Memorandum

To:	Planning	From:	Environmental Health
Officer:	Claire Booth	Officer:	Neil Martin
Reference:	3/2012/0577	Extension No:	3214
Date:	30th July 2012

Planning Application: 3/2012/0577
Location: 44-46 Berry lane, Longridge
Development: Conversion to two shops on ground floor and 2 flats on first floor, plus 2 air heat pumps.

NORTH EAST ELEVATION

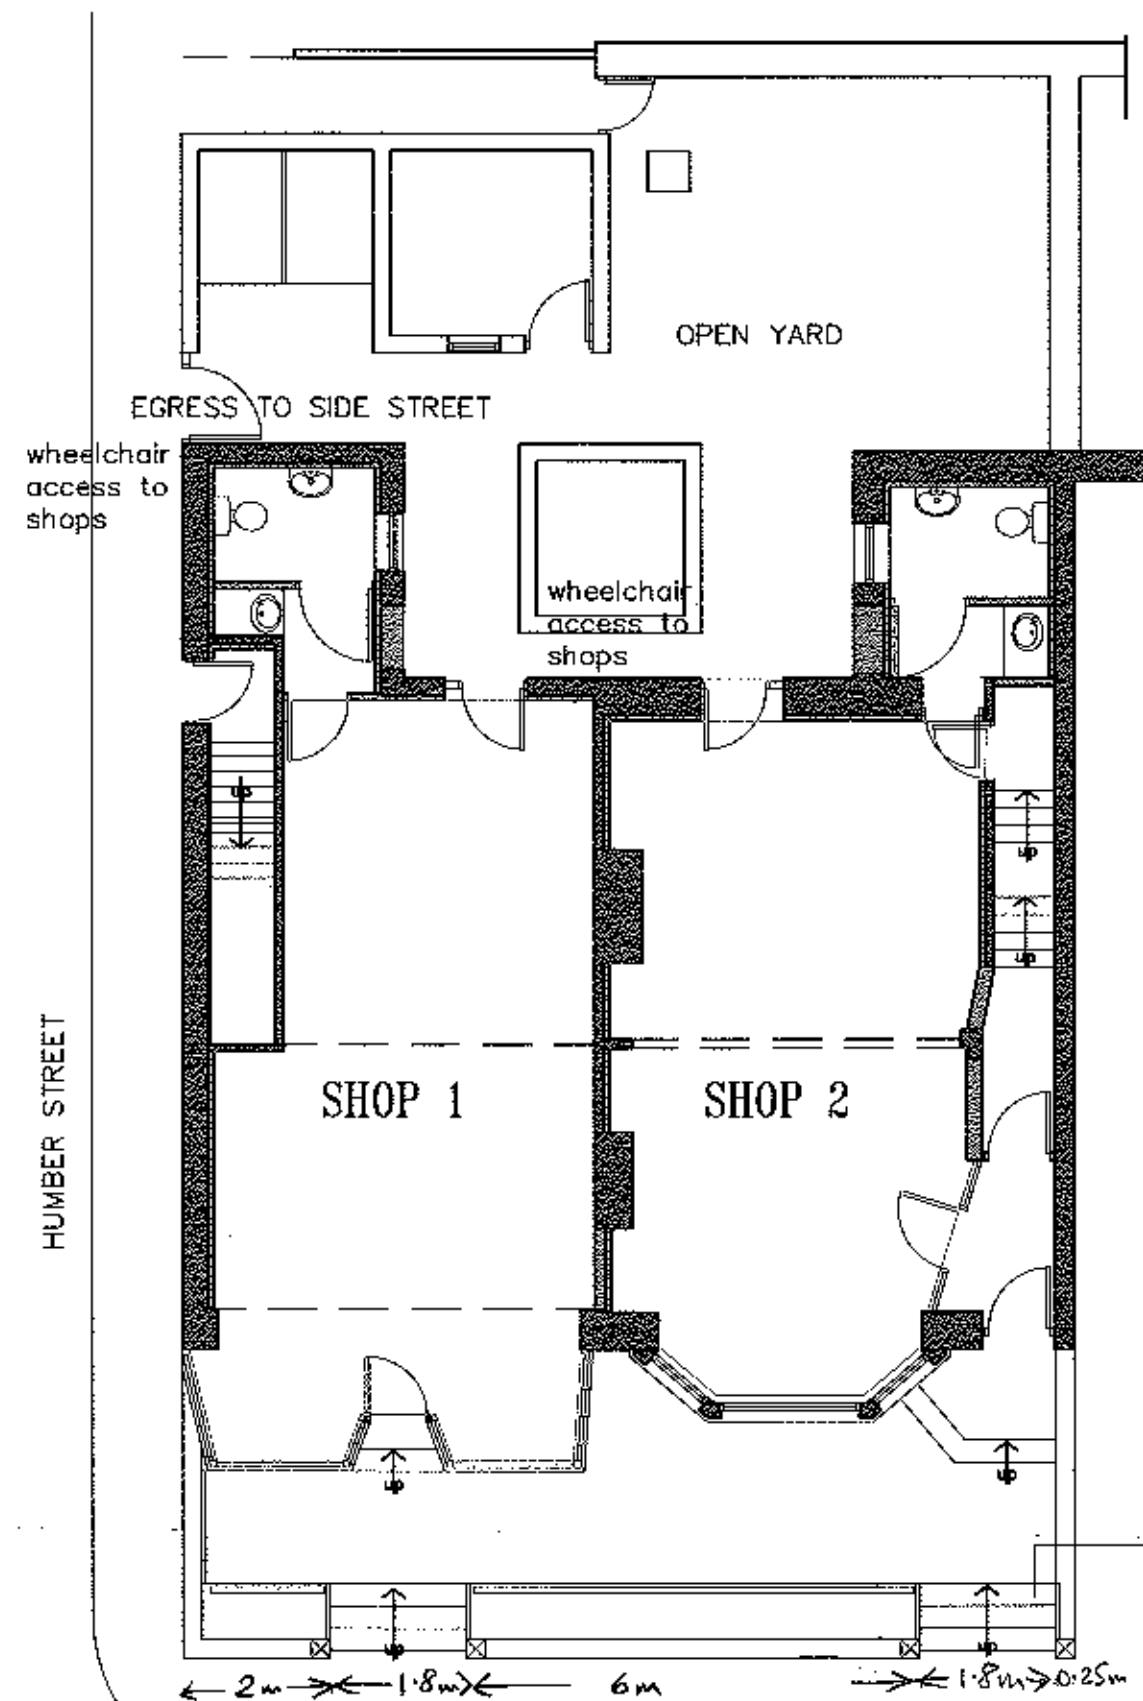
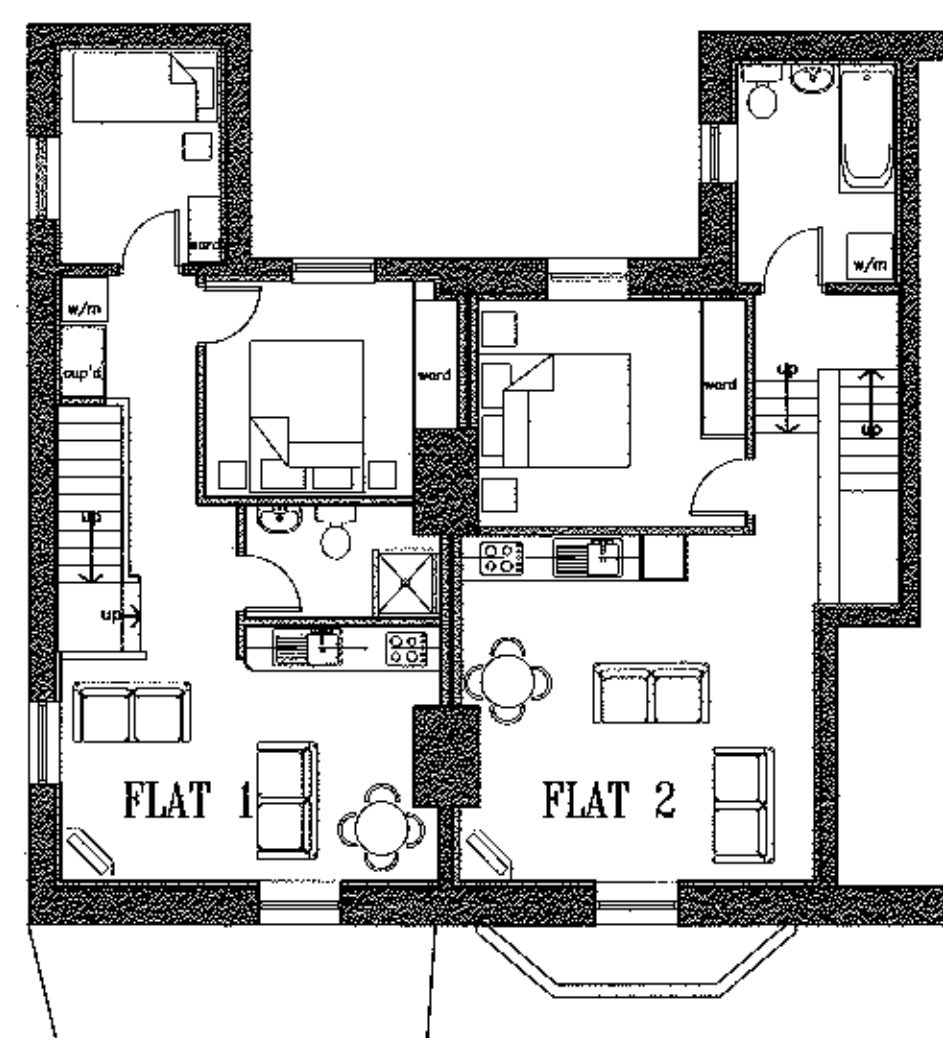
The proposed air-air heat pumps have the potential to adversely affect the amenity of the area due to the noise emissions from them. No details of noise emissions have been provided by the applicant and given the elevated height (first floor level) of the proposed pumps any noise produced could adversely affect any future occupants of the flats or the surrounding residential development.

Until additional information is submitted relating to the noise emissions from the heat pumps a full assessment of the impact cannot be made. I would therefore recommend refusal of the application.
